Arun District Council
Arun Civic Centre
Maltravers Road
Littlehampton
West Sussex BN17 5LF
Planning & Building Control General Enquiries
Tel: (01903) 737756 Fax: (01903) 730442
Dx: 57406 Littlehampton
Minicom: 01903 732765
e-mail: planning@arun.gov.uk
website: www.arun.gov.uk/planning

Application No: WA/63/21/PL
Site Address: Land East of Tye Lane Walberton BN18 0LU
Description of works: Proposed alternative vehicular accesses off Tye Lane and emergency access off Avisford Park Road, along with minor highway works following WA/95/18/RES (resubmission following WA/93/20/PL). This site is CIL Zone 2 (Zero Rated) as other development.

Thank you for your internet representation made on 29th July 2021 which has been recorded as an objection with the comments as follows:

Drawing Title:
PROPOSED ALTERNATIVE ACCESS

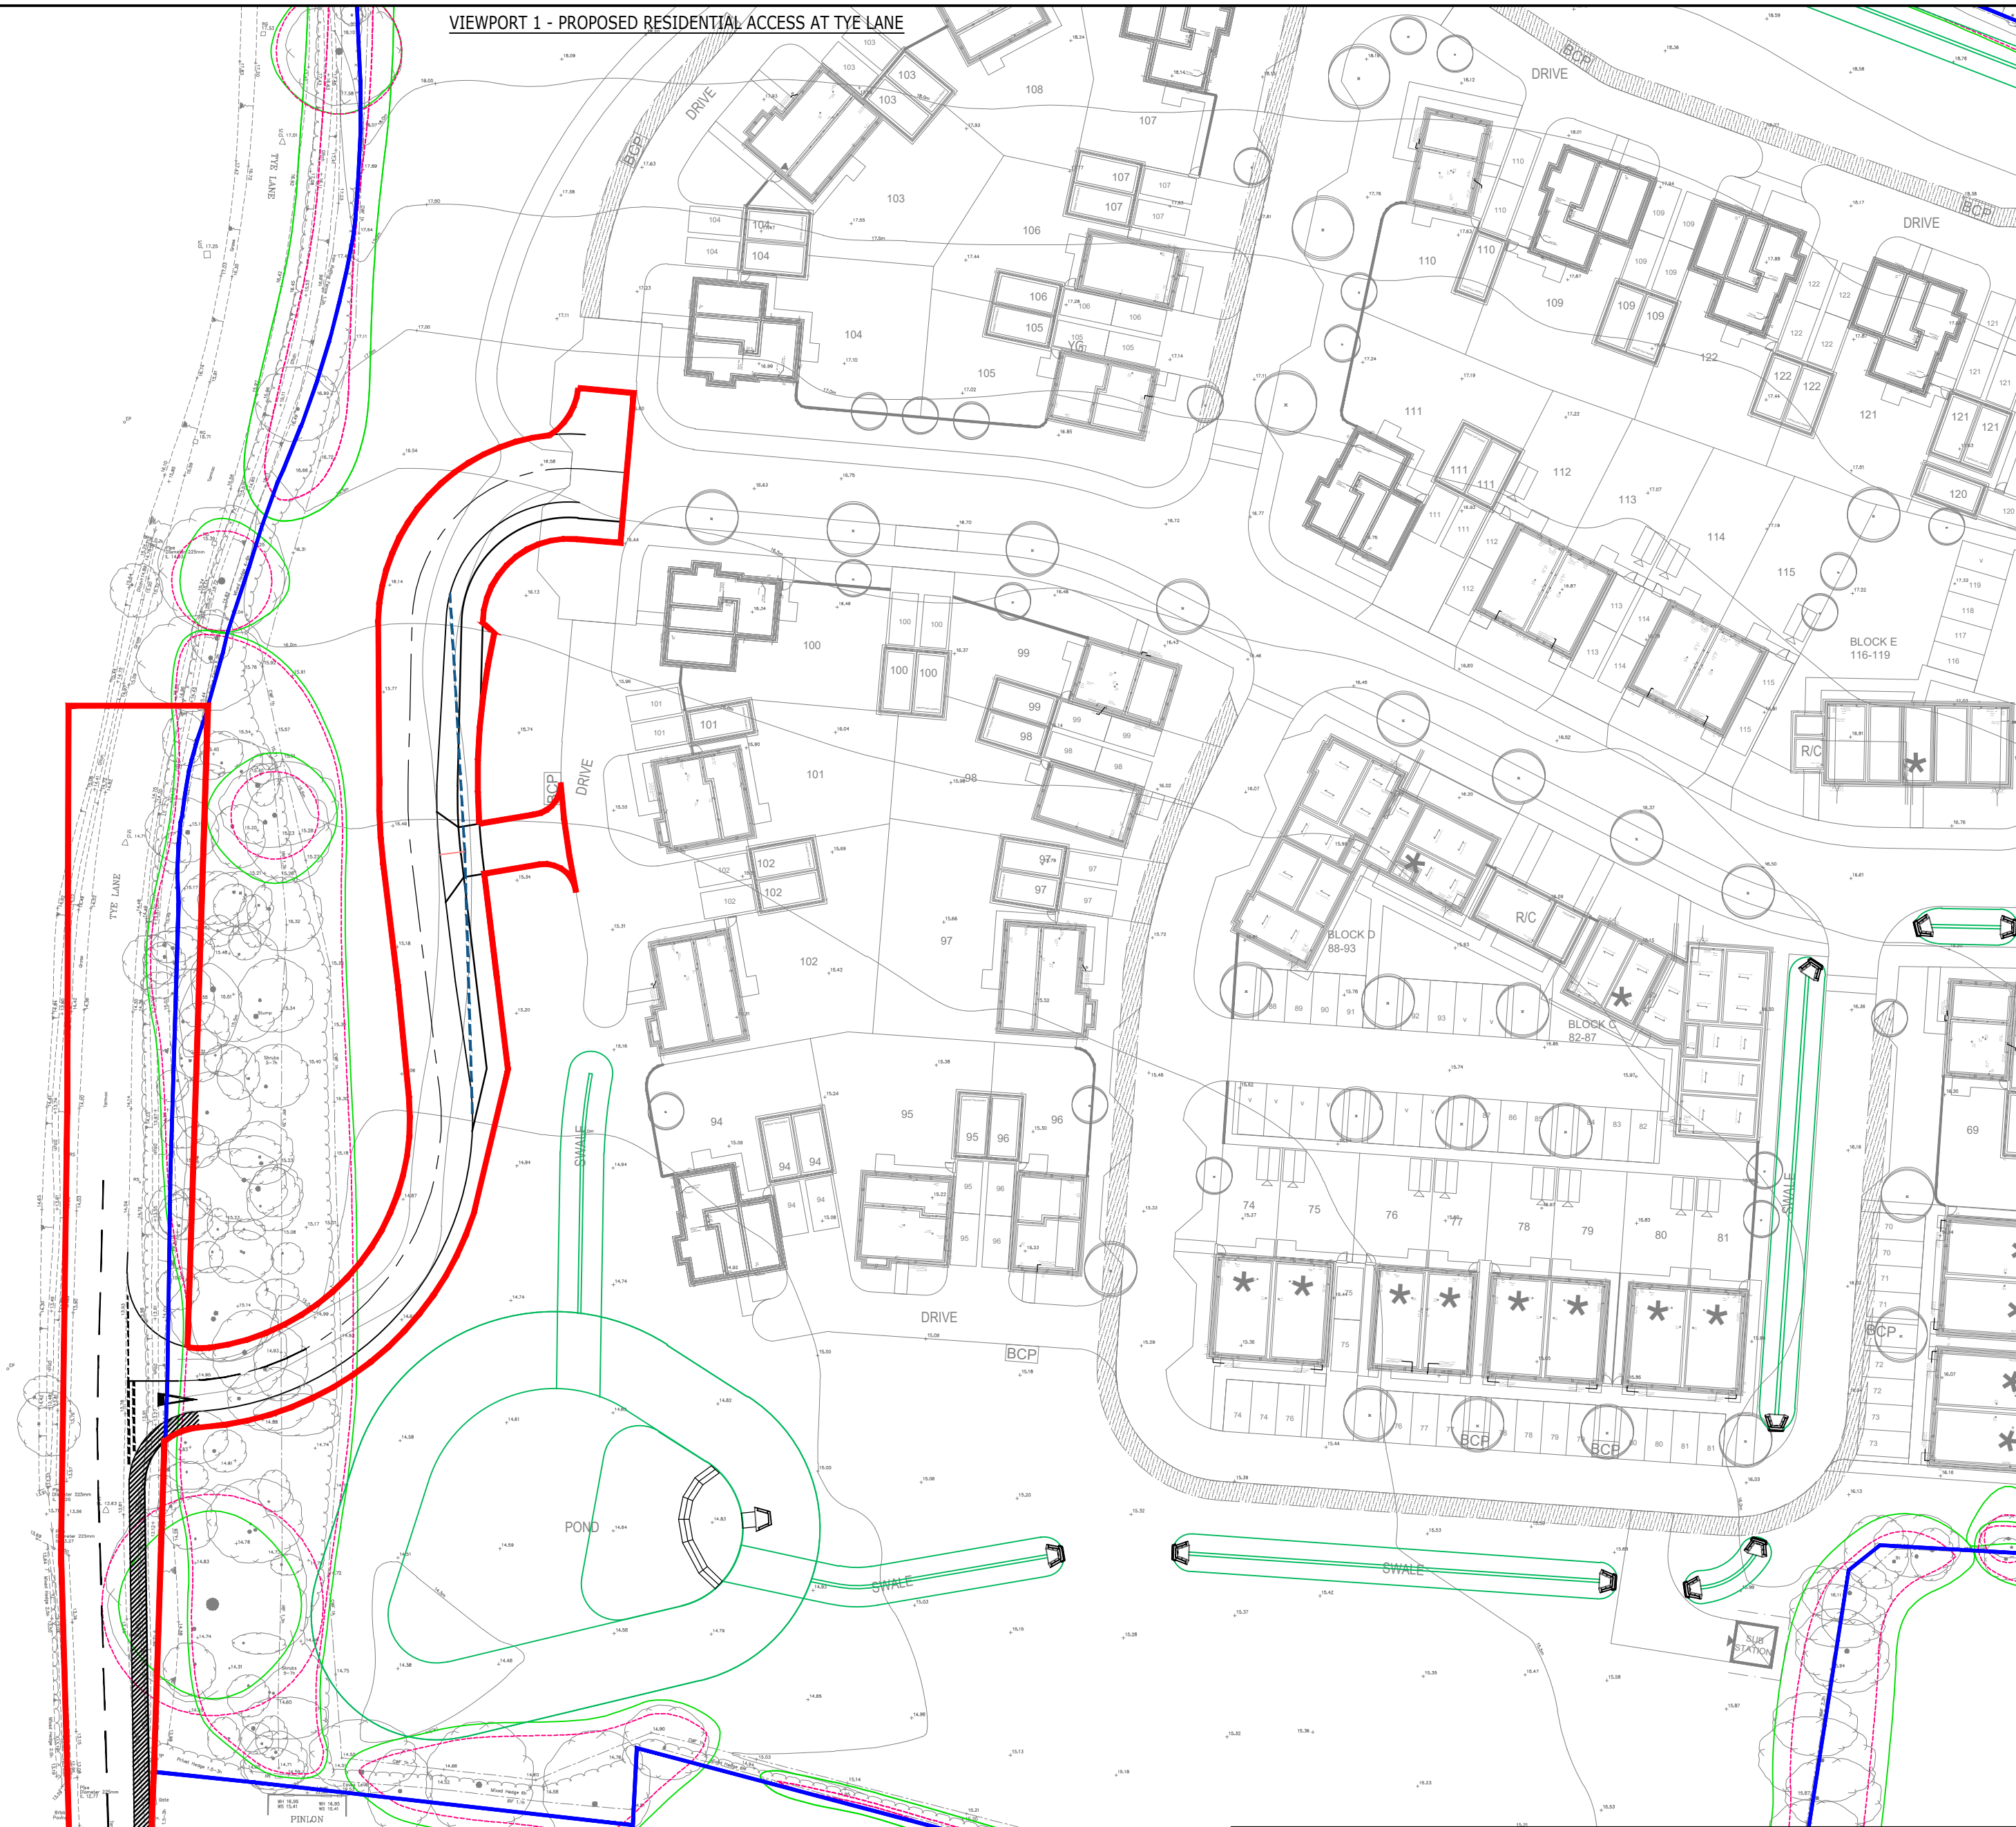
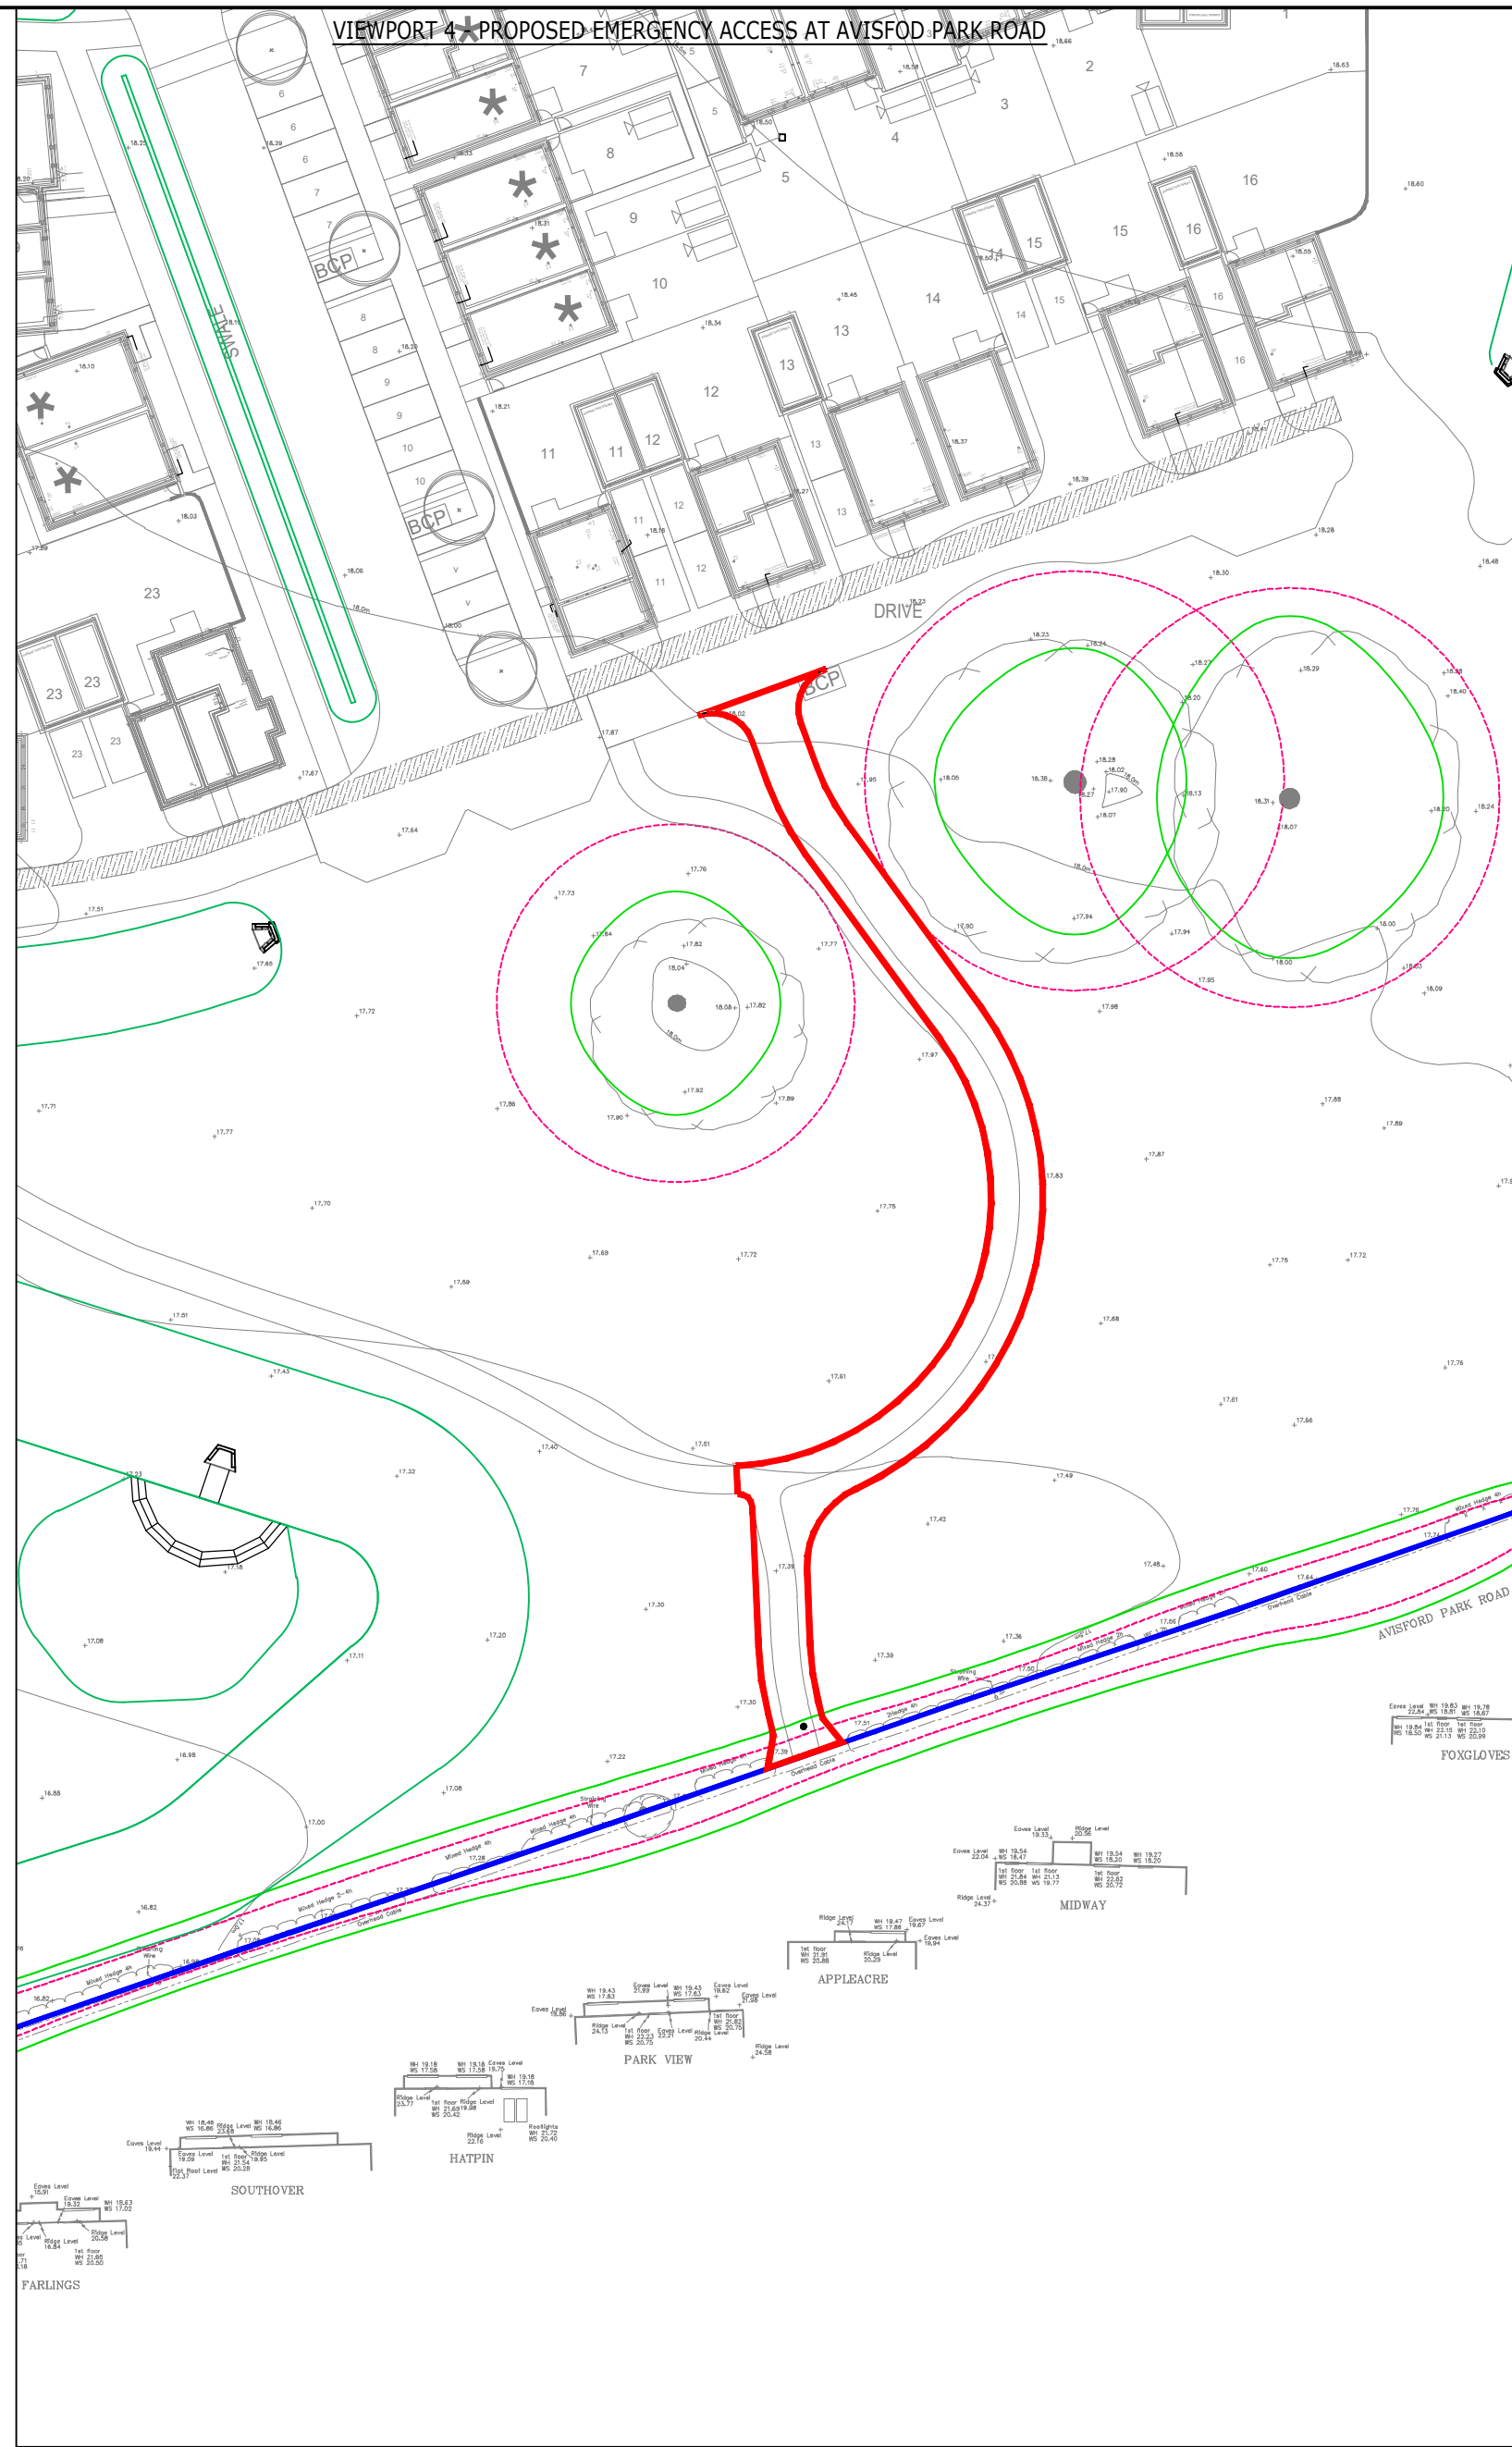
Tye Lane is totally unsuitable for the traffic likely to be generated by 175 new homes (perhaps 300/400 vehicles) and, indeed, such traffic will totally destroy the peace of the village, whether it turns left or right into the Street.
